RE: PICTON HIGH SCHOOL RESPONSE TO SUBMISSIONS – RMS COMMENTS

We write with regard to Picton High School Redevelopment (SSD 17_8640), specifically in response to your email dated 12 December 2018 requesting responses to comments raised by RMS following the lodgement of the Response to Submissions package (dated 30 October 2018).

RE: PICTON HIGH SCHOOL RESPONSE TO SUBMISSIONS

: 2500

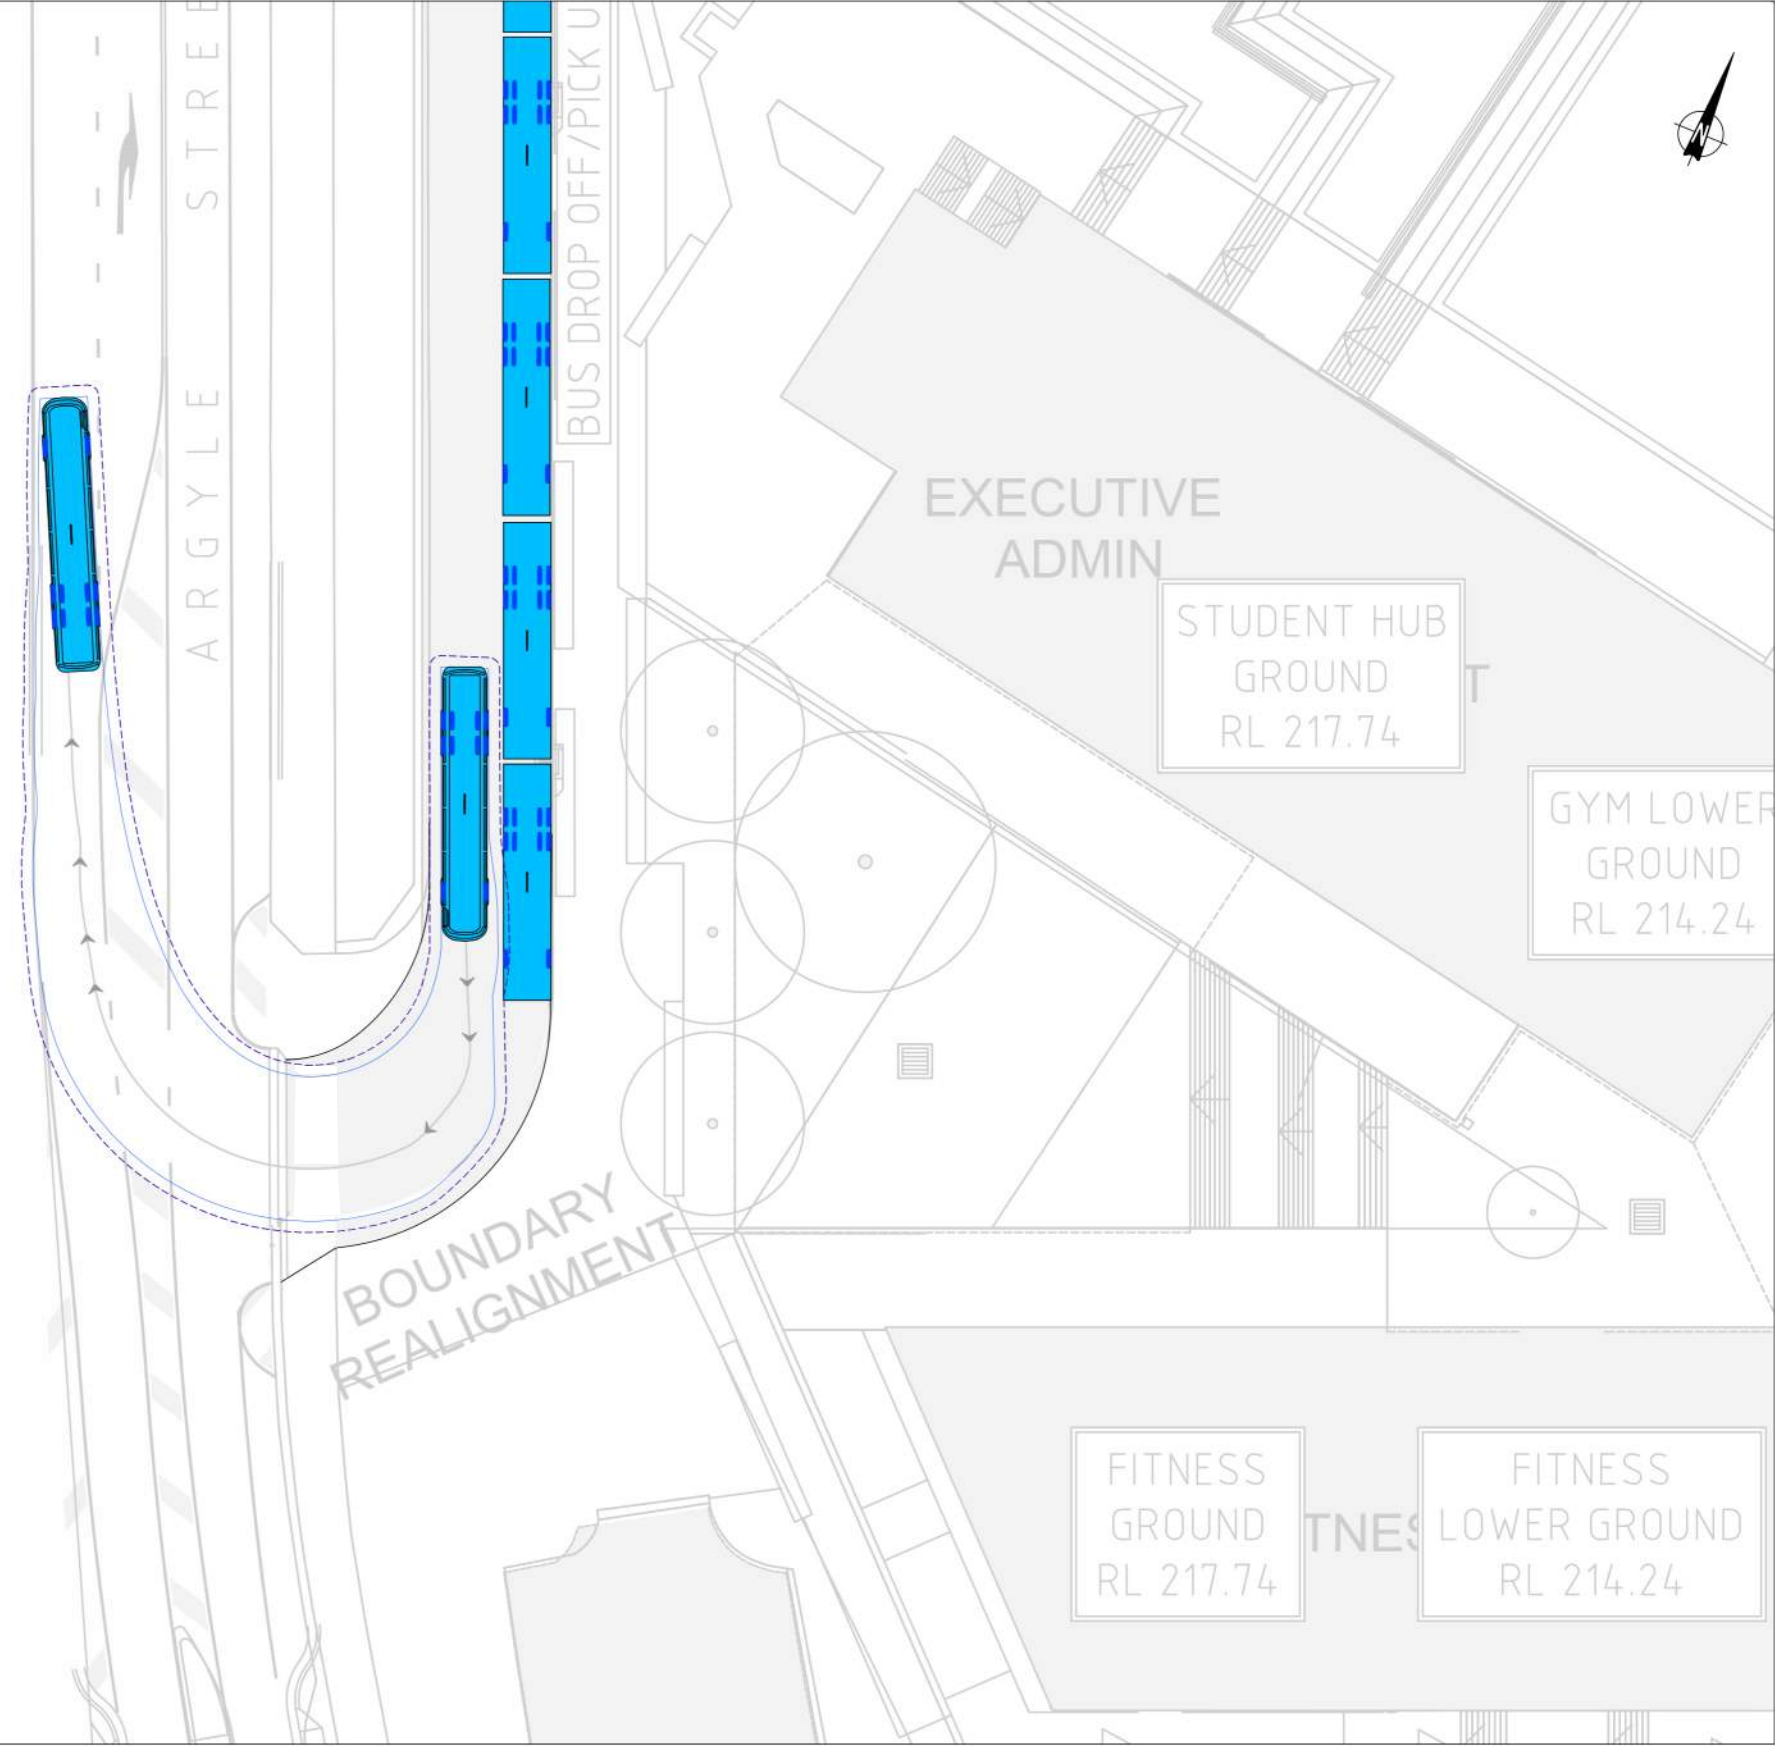
<p>Swept Path Assessment</p> <p>RMS notes that the updated <i>Traffic and Accessibility Impact Assessment</i> (prepared by TDG, Ref: 14584 ta 180803 final, dated 3 August 2018) contains updated turning manoeuvres for buses entering and leaving the site. As detailed in RMS' previous advice the plans provided should comply with Austroads requirements (e.g. speeds used, required clearances, etc). The following comments are provided on the updated plans:</p> <ul style="list-style-type: none"> • The turning path for the bus entering the bus parking area fronting Argyle Street from the north does not appear to have been applied correctly. The radii used are too tight with the vehicle turning at too low a speed. If applied correctly the bus would not be able to park in the last parking space without reversing and manoeuvring into the position; • The bus turning from the right turn bay cannot enter the parking area without the front overhang crossing onto the footpath; • The turning path for the bus exiting the bus parking area to the north has not been applied correctly. The radii used are too tight with the vehicle turning at too low a speed; 	<p>As shown in Attachment B (swept path analysis at 5km/h) this will be the maximum design bus that will be used on-site. The bus access arrangement has been revised to avoid the front overhang.</p> <p>The bus vehicle turning path has been designed in accordance with the 'Austroads 2013 – Design Vehicles and Turning Path Templates Guide'.</p> <p>As specified in the Austroads Guide, the long rigid bus of 14.5 metres long, is designed to a speed of 5km/h.</p> <p>In addition, we have also prepared the bus movement at a design speed of 10km/h (refer to Attachment C).</p> <p>The bus operations (loading and unloading of students) will be managed by staff to ensure students get on the correct bus service, and fill up the first bus before proceeding with the second bus.</p>

Issue	Response
<ul style="list-style-type: none"> When the turning paths are applied correctly a bus is unable to enter the bus parking area if another bus is occupying the end parking space. This could cause queuing onto Argyle Street; If the number of buses shown within the Argyle Street bus pick up/drop off area are to be contained within this area then they would have to exit in the same order as they arrive (i.e. no space between the buses to allow them to manoeuvre into or out of their space if other buses are occupying the adjacent spaces). This has the potential to cause congestion which will impact upon the operation of Argyle Street; <p>Noting the comments above RMS believes that the applicant should be requested to provide the above detail to council for review and comment prior to the determination of SSD 8640.</p>	
School Zones	
<p>RMS notes that the RTS covering letter prepared by Ethos Urban (dated 30 October 2018) details, in part, that the determination of the school zones required (i.e. new school zone and/or amendments to the existing school zone) will be addressed following approval of the current SSD application. While this is correct, it has now become apparent that a temporary school is being established on the site with access to be gained from Wonga Road. The details of the temporary school were not discussed in any detail in the information that has been provided to date. While RMS acknowledges that the temporary school does not form part of the current SSD application, if it is intended to occupy the temporary school at the start of the 2019 school year RMS advises that the new school zone for Wonga Road and associated speed zone reductions will need to be in place before the commencement of use of the temporary school. The new school zone in Wonga Road to be determined in consultation with RMS's Road User Safety Project Officer. It is therefore requested that DPE inform the applicant that they should make contact with Amanda Priestley at RMS on 4221 2517 to further progress the new school zone that will be required in Wonga Road to service the proposed temporary school.</p>	<p>Stephen Craig from Taylor Construction has contacted Amanda Priestley regarding the School Zones on Wonga Road (refer to Attachment D). A concept School Zone plan has been prepared (refer to Attachment E).</p>
